Application for Planning Permission for Works or Extension to a Dwelling

Development Single storey extension.

Location 42 Barrack Lane Aldwick

block plan

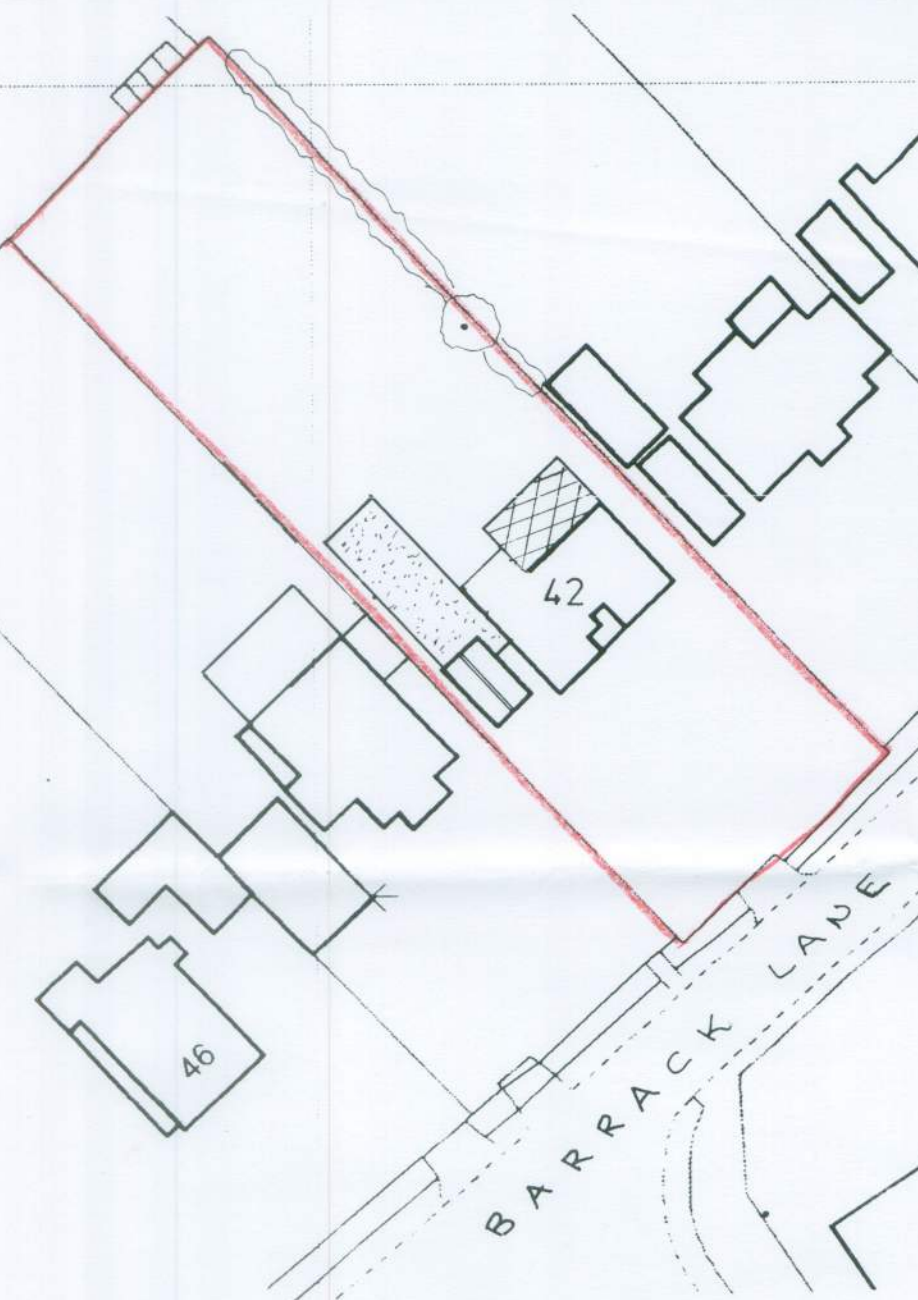
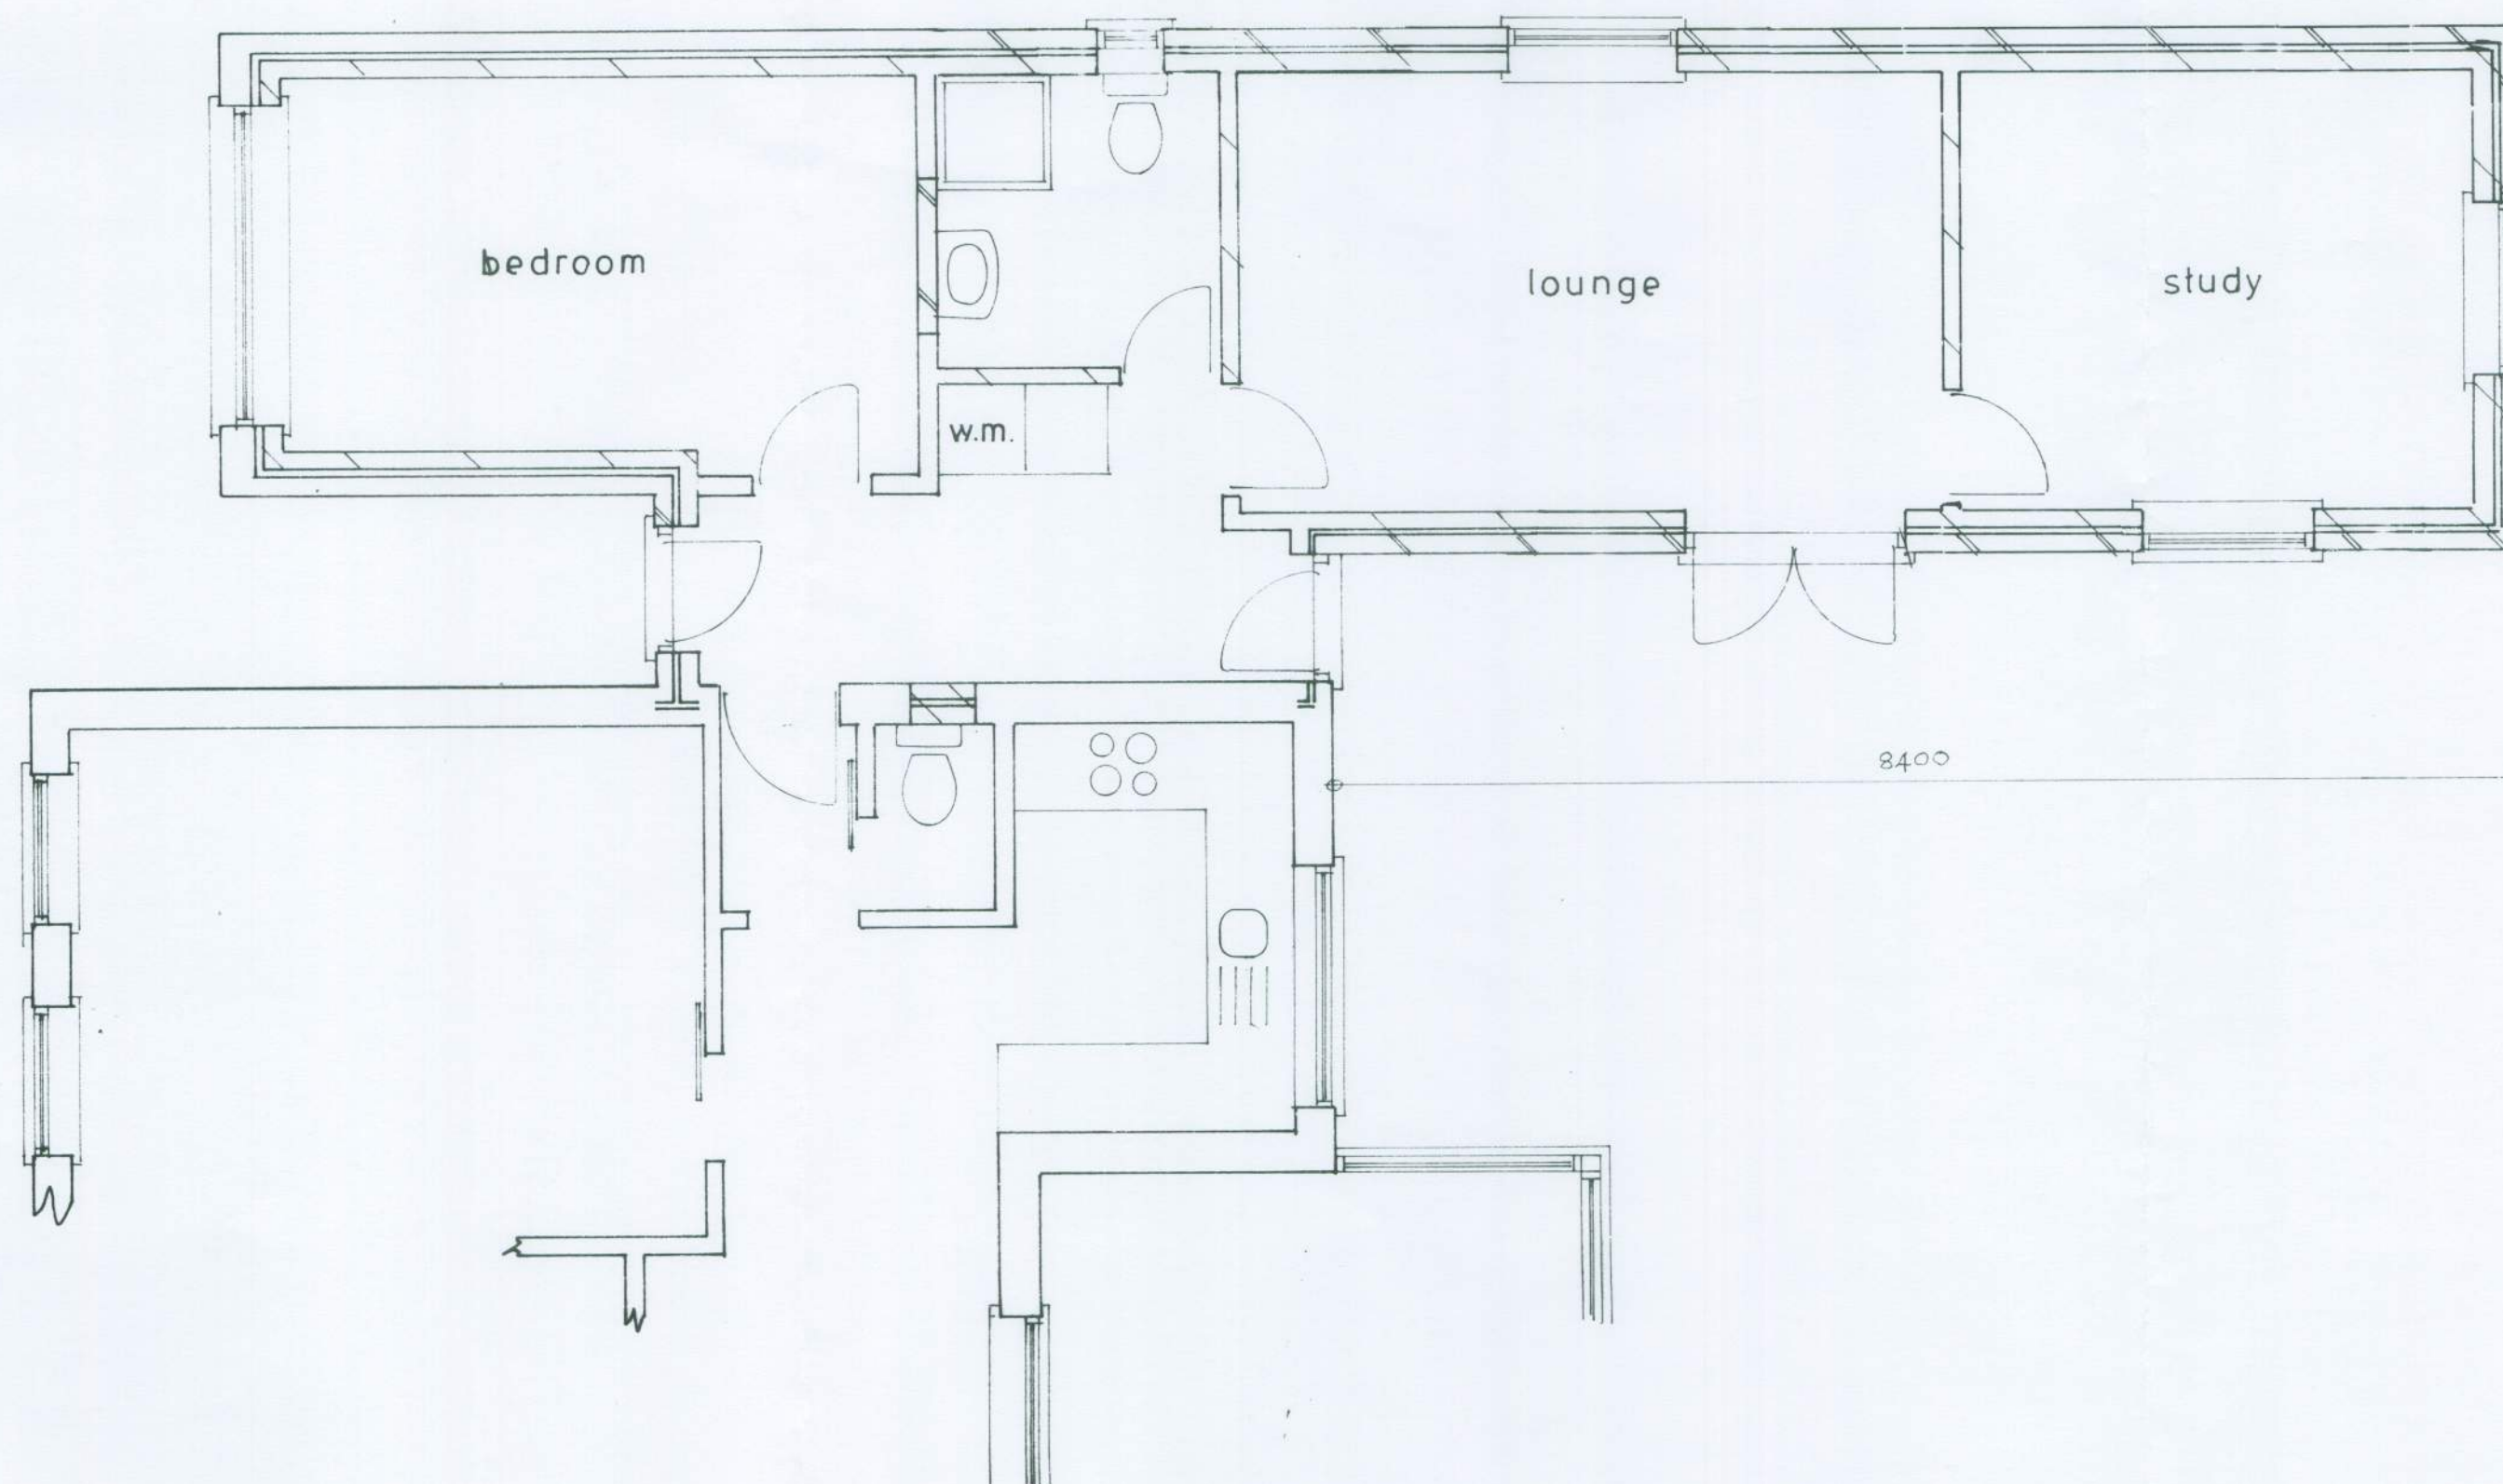
Please submit amended block plans. The plans submitted are not clear enough as to which part of the building is being extended.

sheet 2 of 3

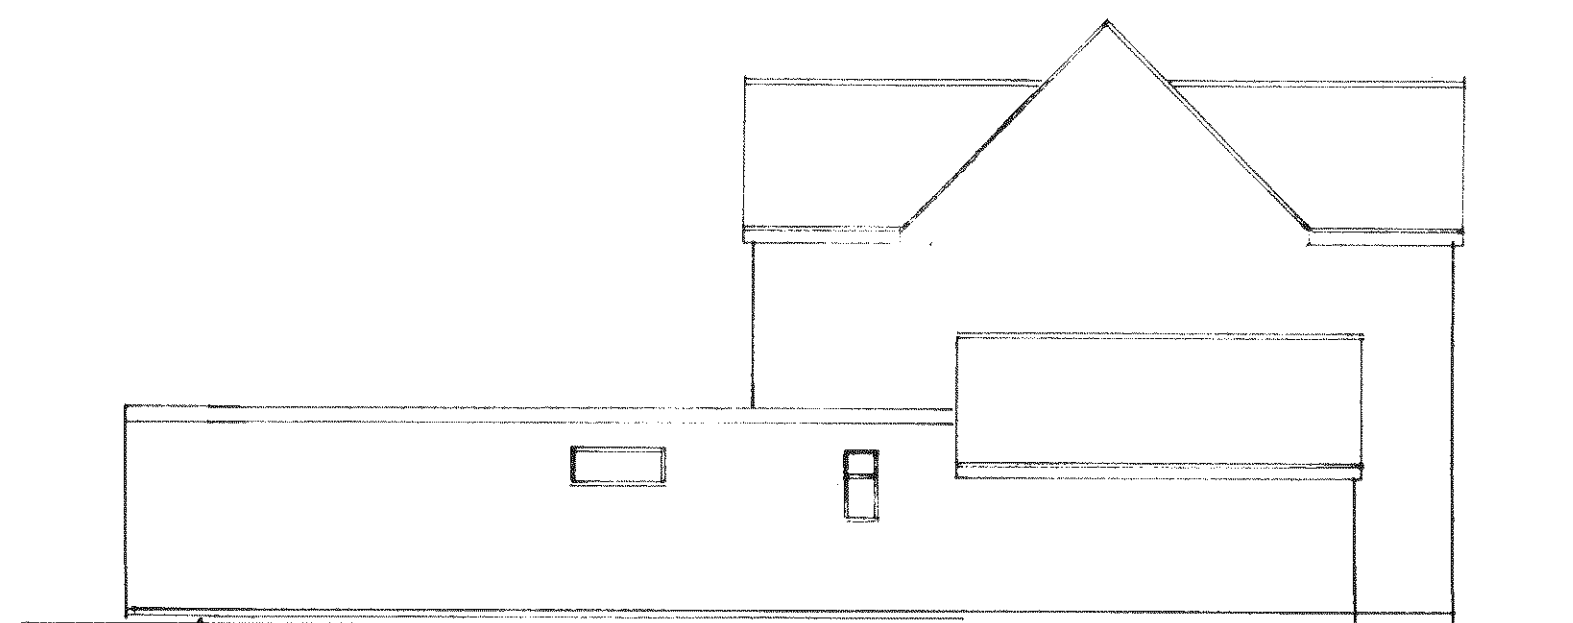
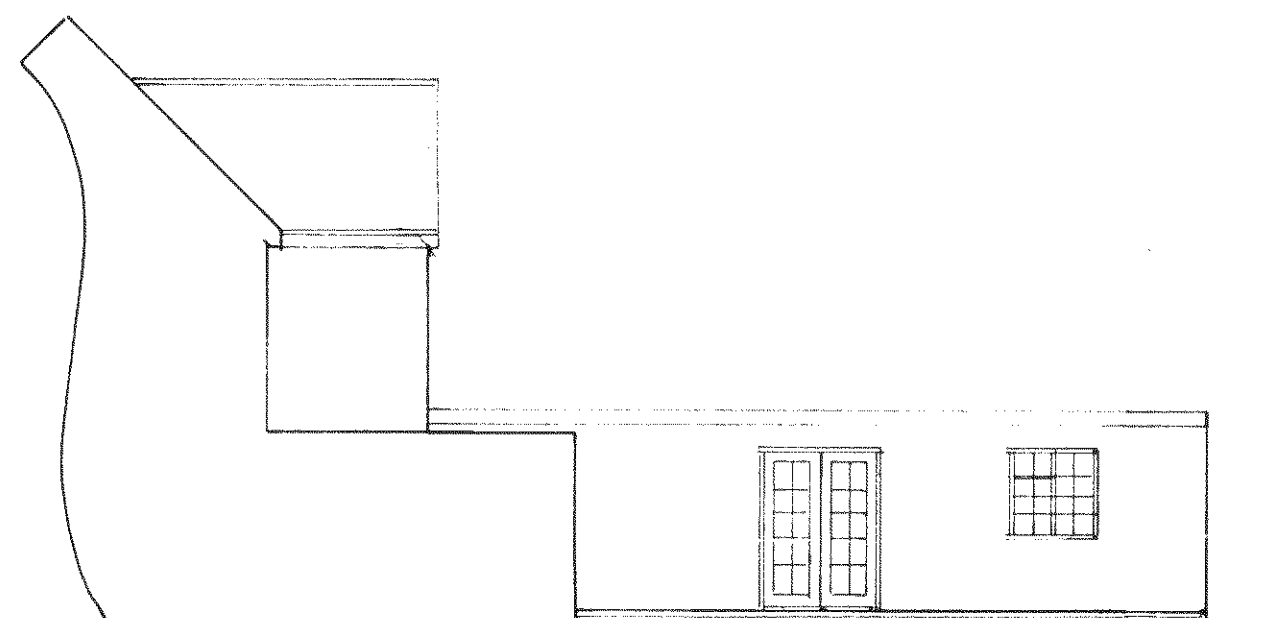
Please confirm what elevation the extension will be constructed
